Planning Application Ref: BE/180/16/PL (4)

Location: Land adj. to 2 North Bersted Street, Bognor Regis

Description of works: Construction of 1 No two storey dwelling on a narrow storage yard

Comments On Appeal Statement:

Tree Constraints Plan
North Bersted Street, North Bersted, Bognor Regis

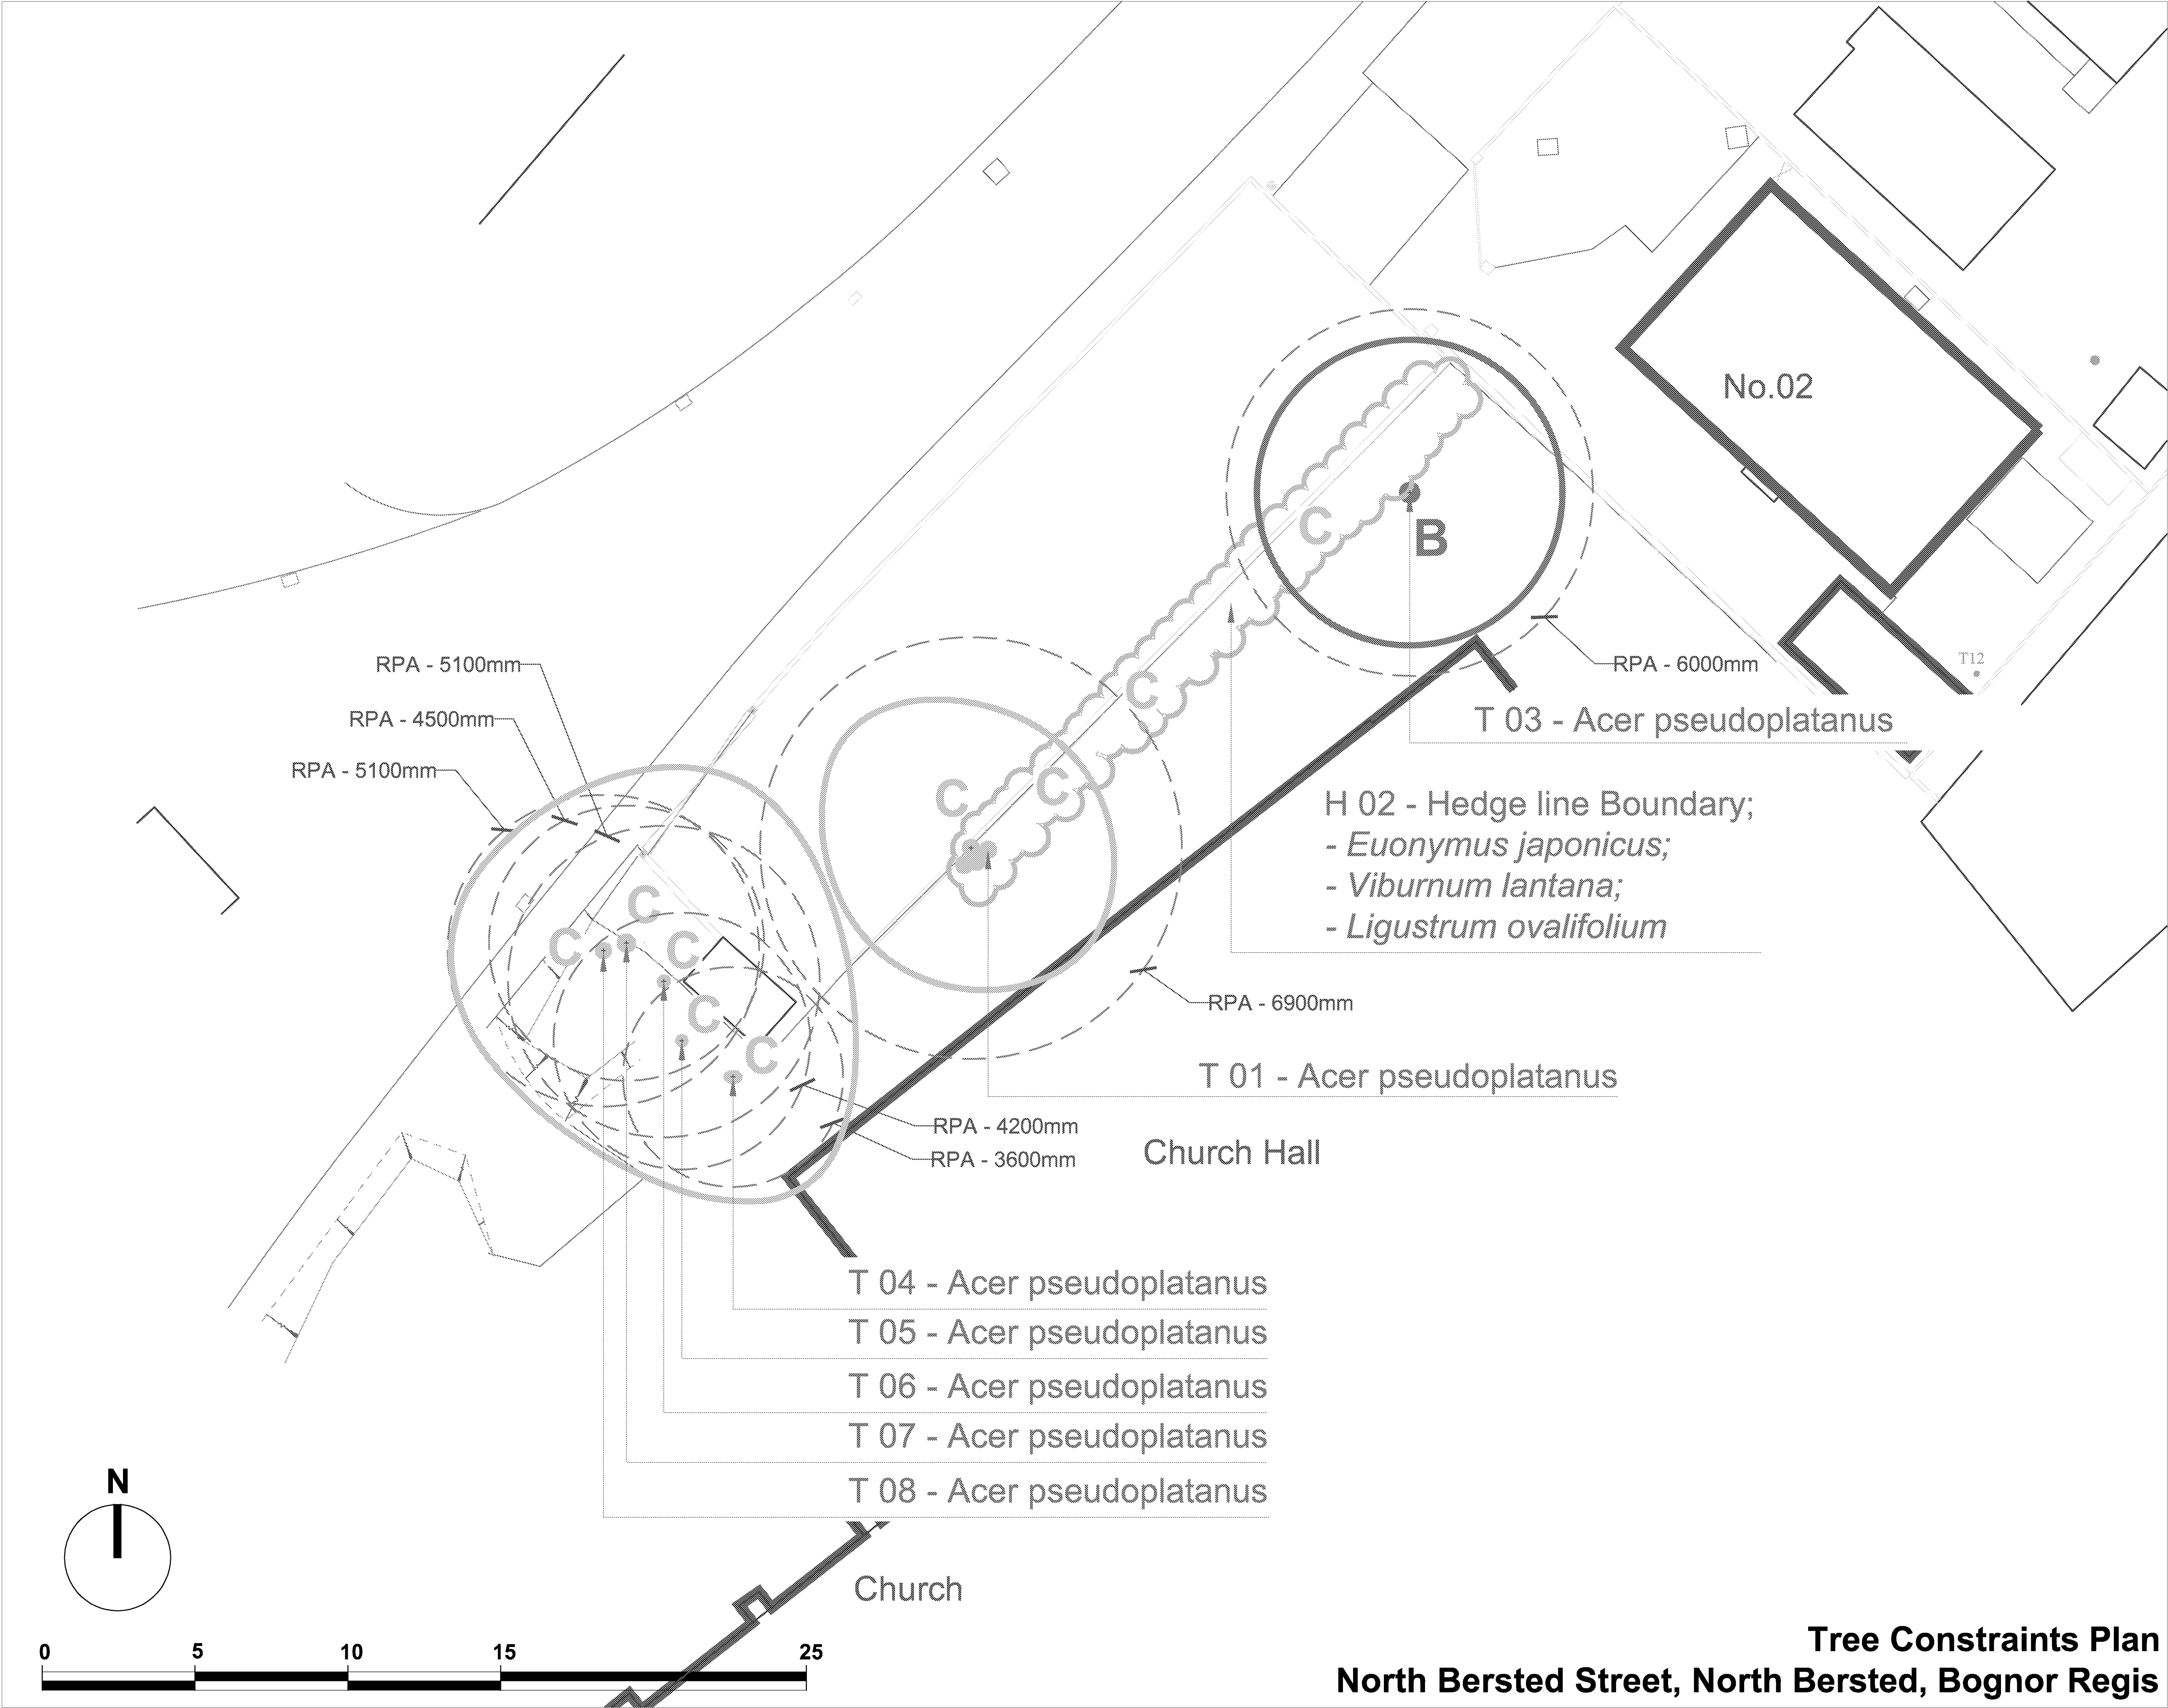
- ‘...pressure to heavily prune or indeed fell the existing trees would have no effect as the trees are not within the control of the applicants or future occupants.’ And this is my point – they can and indeed have cut back to the boundary line all current branch overhang from these trees BUT they are only young trees and have considerable growth potential and could be 20m high trees at maturity with 8m to 10 radial spread closing off the existing gap along the boundary between trees at the present time. Whilst the new resident can continue to cut back to the boundary line to keep this growth off the property they can do nothing more as they do not own or control the trees – thus they will want more light as the trees are due south of the proposed development = pressure will be applied to the trees owners to have them heavily lopped and topped or removed!

- ‘This completed work results in the removal as far as possible of the future irritant of leaf dropping, sticky sap and seeds falling into the proposed garden space..’ Yes they can cut back the current growth but as they state ‘as far as possible’ thus it does not completely remove the problems - it just seeks to reduce their impact.

- ‘1) There is a significant gap in the run of trees at the southern corner of the site allowing sunshine into the garden in the middle of the day.’ They are only young trees and have considerable growth potential and could be 20m high trees at maturity with 8m to 10 radial spread closing off the existing gap along the boundary between trees at the present time and there is nothing the resident will be able to do about this other than apply ‘pressure to prune or fell’ on the trees owners.

- As things stand I would have to sustain an **OBJECTION** to this scheme as I feel that the relationship of trees to dwelling would inevitably lead to conflict and ‘pressure to prune or fell’ these trees.
- In essence it boils down to the fact that in my opinion trees and dwelling cannot exist in harmony here so you either have one or the other but not both.
